November 2, 2018

Re: La Sigueria
1809 San Pedro Dr. NE
Traffic Circulation Layout
Engineer's/Architect's Stamp **09-27-2018 (J18D047)**

Based upon the information provided in your submittal received 10-31-2018, the above referenced plan cannot be approved for Building Permit until the following comments are addressed:

SITE PLAN FOR REFERENCE

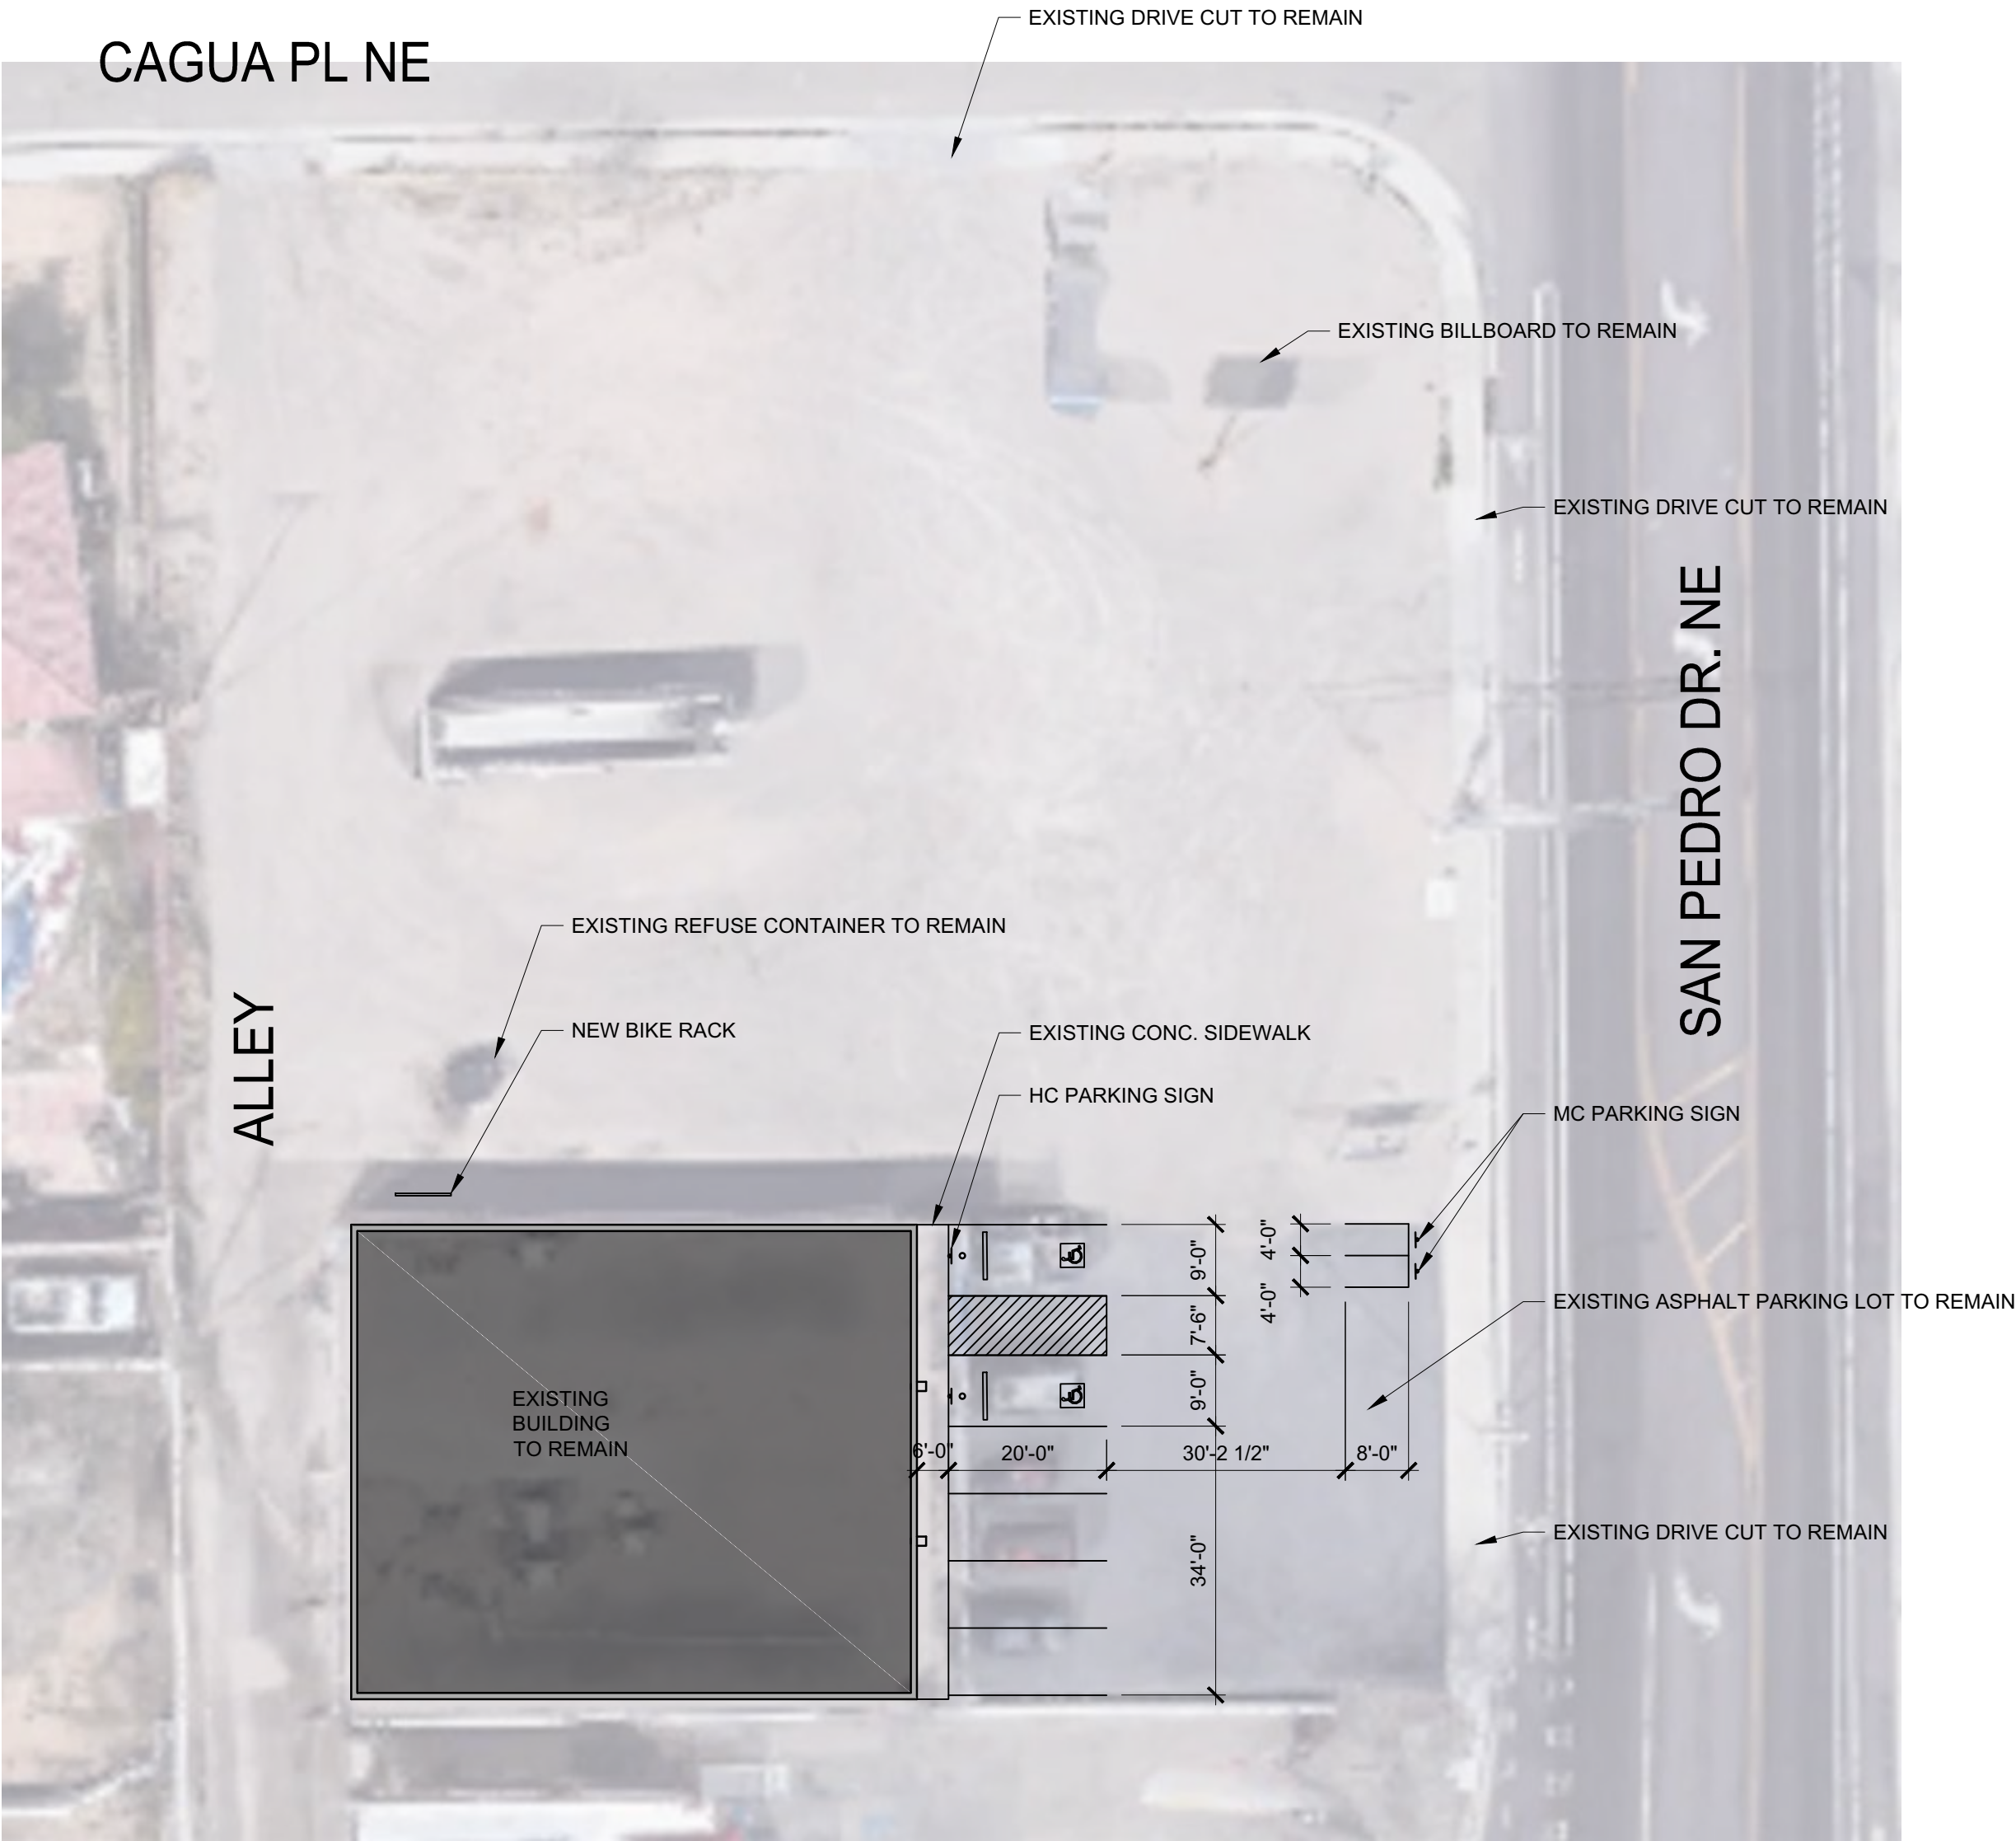
- Specify the dimensions for all the access points (existing drive cuts).
- Verify the distance of the curb cut to the intersection.
- Clarify existing property lines.

- Please submit a work order for pavement.
- The ADA access aisles shall have the words **"NO PARKING"** in capital letters, each of which shall be at least one foot high and at least two inches wide, placed at the rear of the parking space so as to be close to where an adjacent vehicle's rear tire would be placed. (66-1-4.1.B NMSA 1978)

- ADA curb ramps must be updated to current standards and have truncated domes installed.
- The pedestrian acces in front of the building should be 6' wide.

- Per the zoning code, a 6 ft. wide ADA accessible pedestrian pathway is required from the public sidewalk to the building entrances. Please clearly show this pathway and provide details.

- It is not apparent what type of pavement surface is being proposed. A hard driving surface will be required as part of this proposed project for parking area and drive aisles.

- Consider moving the billboard. It seems to be in the middle of the driveway
- provide a copy of refuse approval.
- The curb cut in the south-west corner should be closed.
